Major Projects Assessment
GPO Box 39
SYDNEY NSW 2001

RE: STATE SIGNIFICANT INFRASTRUCTURE – EPPING TO THORNLEIGH THIRD TRACK (SSI-5132) - REQUEST FOR COMMENT ON ENVIRONMENTAL IMPACT STATEMENT

Vincent Sicari

Figure 132: Devlins Creek area of archaeological potential.

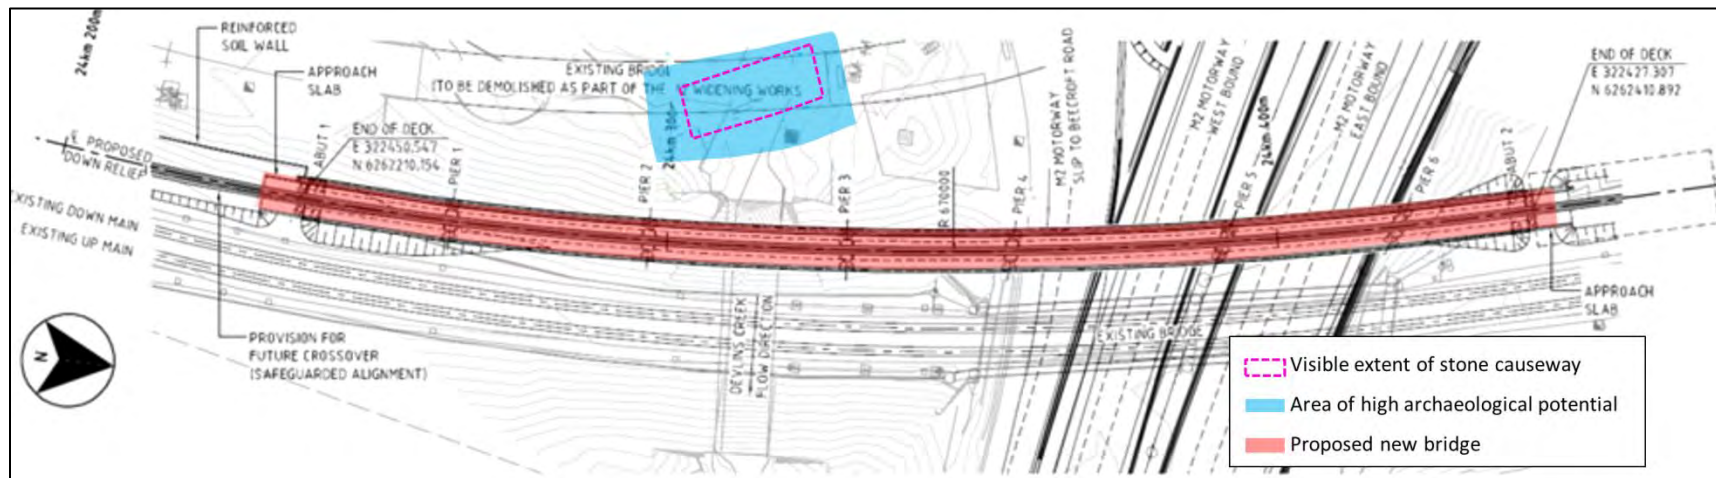
Although the works will not impact the causeway itself the proponent has identified that its location will be marked on all site plans and in the CEMP and the site monitored for vibration damage during construction works. Although the documentation states that the causeway will be monitored for vibration impacts there is no discussion of measures to be followed should vibration damage be identified. Although this could have been addressed in the CEMP the proponent has not provided one at this stage.

- The causeway over Devlins Creek should be fenced off during works to help identify its location on the ground and minimise potential accidental damage; this should be included as a condition of consent.

- The EIS has provided no procedures to be followed should vibration damage be identified on the causeway stating that investigation is to be undertaken. Any conditions of consent and the CEMP should specifically state that if any vibration damage to the causeway is identified works are to stop while investigation of the damage and potential options to minimise further damage are undertaken. Furthermore any damage to the causeway is to be reported to the Heritage Council immediately.

Concept design drawing of proposed changes to Beecroft Station (Parsons Brinckerhoff 9/3/12). Former side platform shaded in pink.

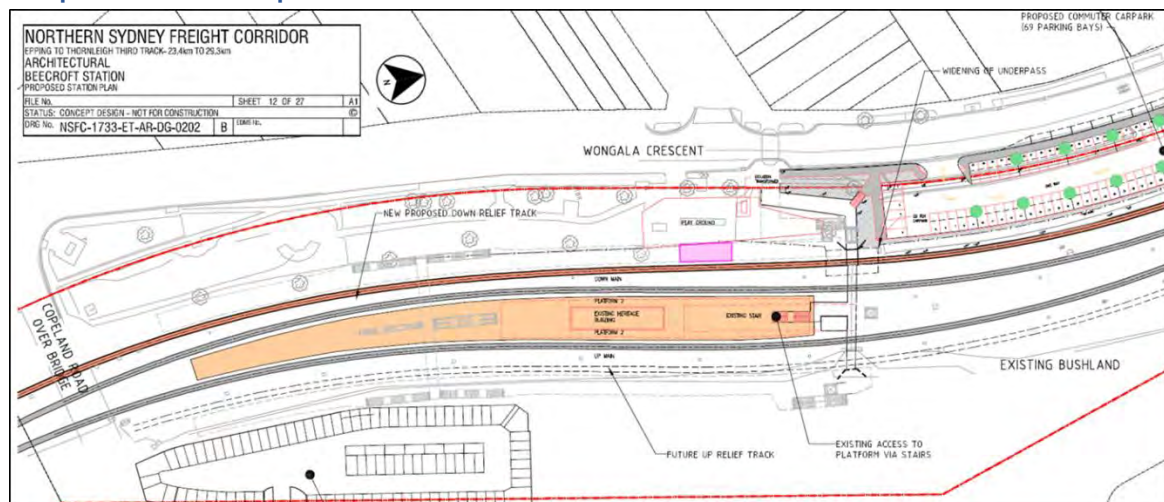
The works will involve the removal of the 1895 platform to facilitate the third track. This 15m long brick lined platform is in relatively good condition but in the past has been planted with a garden that is now overgrown; it is not identified as a significant element of the station. Even if the third track did not require the removal of this station element its construction would further isolate it from the main station.

The Heritage Council considers, on balance, that the loss of the 1895 platform would be acceptable in terms of the impacts on the heritage significance of the site. The proposed archival and photographic

recording of the site prior to demolition is considered acceptable. The applicant should be made to install appropriate interpretation at the site that allows its history and former platform configuration to be able to be interpreted.

- All identified mitigation measures for non-Indigenous heritage items are to be implemented in the CEMP.
- Appropriate interpretation should be installed at Beecroft Railway Station that allows its history and former platform configuration to be able to be interpreted; this should be included as a condition of consent.
